29 January 2025

Ref: EN010115

**Re: The Infrastructure Planning (Examination Procedure) Rules 2010 – Rule 17
Application by Five Estuaries Offshore Wind Farm Limited for Development Consent Order
Request for Further Information Regarding Deep Water Routes (DWRs) and Export Cable
Installation**

Figure 2.1: Overview of area of interest for NIP (including concurrent activity areas).

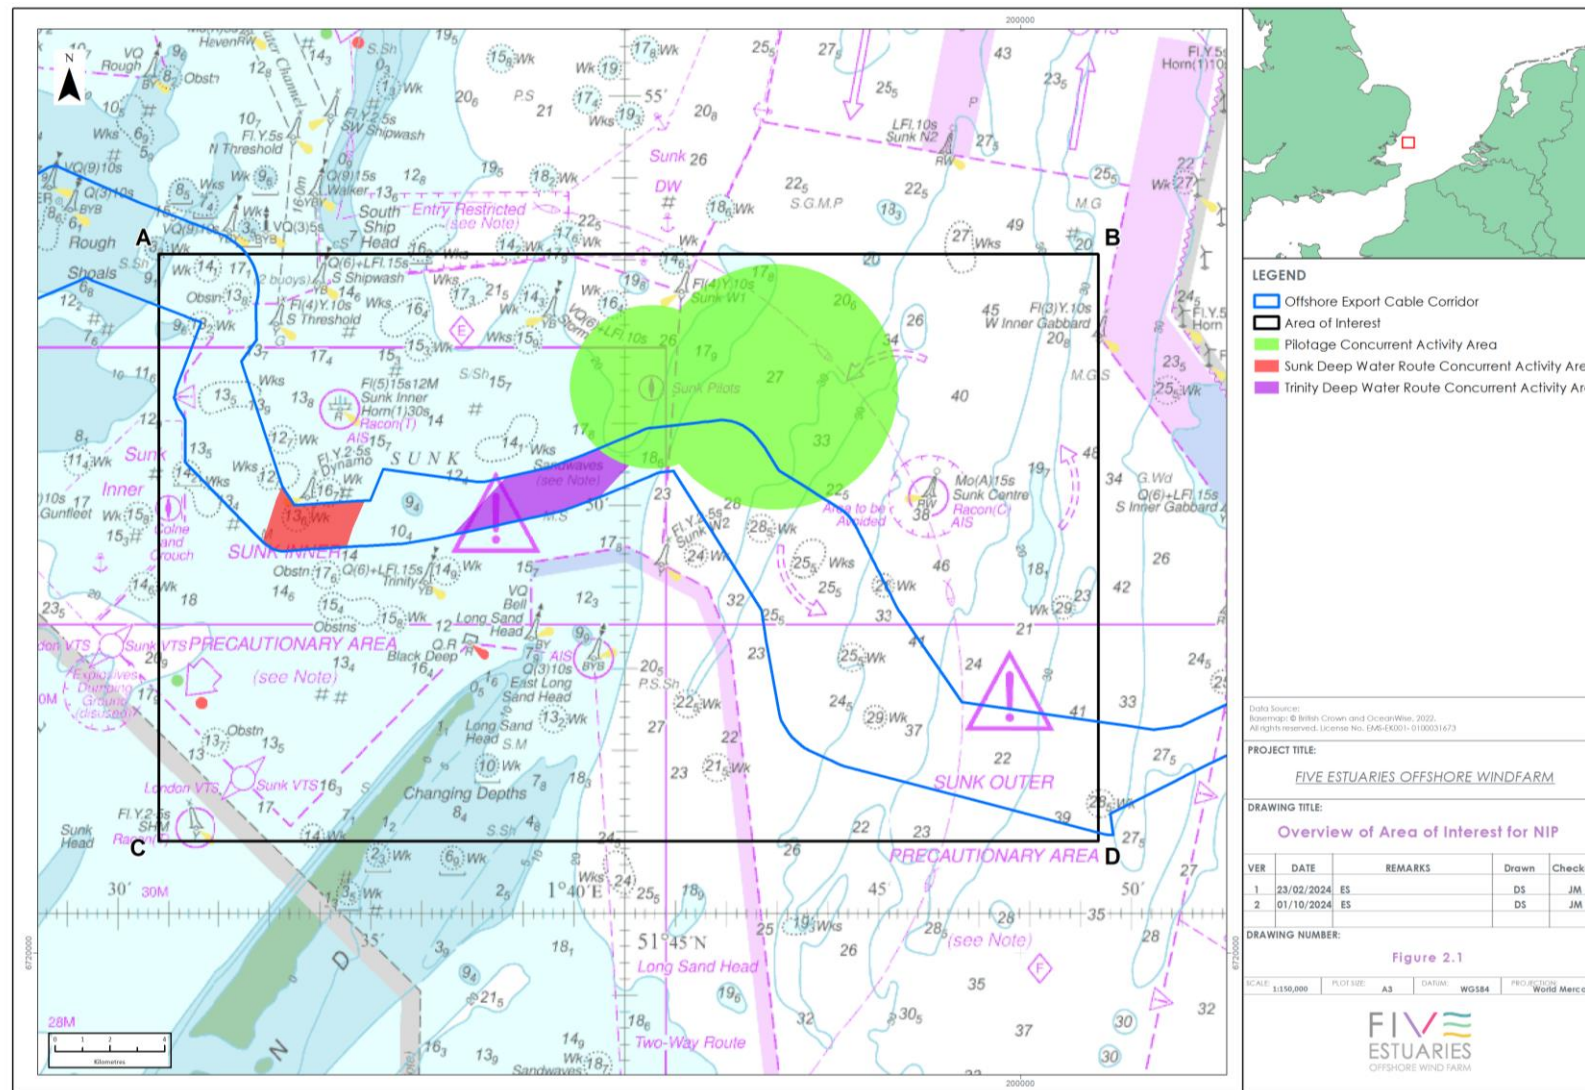
We recommend that the area plan (shown below), which is based on a section of UKHO Admiralty Chart number 2052 and is currently used to illustrate pilotage concurrent activity within the Navigation Implementation Plan, be adapted to clearly depict the specific location of the requirement. This adaptation would ensure that all relevant stakeholders have a precise visual reference for the affected area, aiding in the effective implementation and enforcement of the requirement within the Development Consent Order.

The plan should be directly referenced in the DCO Schedule 2 Requirement 2 and the Schedule 11 DML to provide clarity and ensure enforceability.
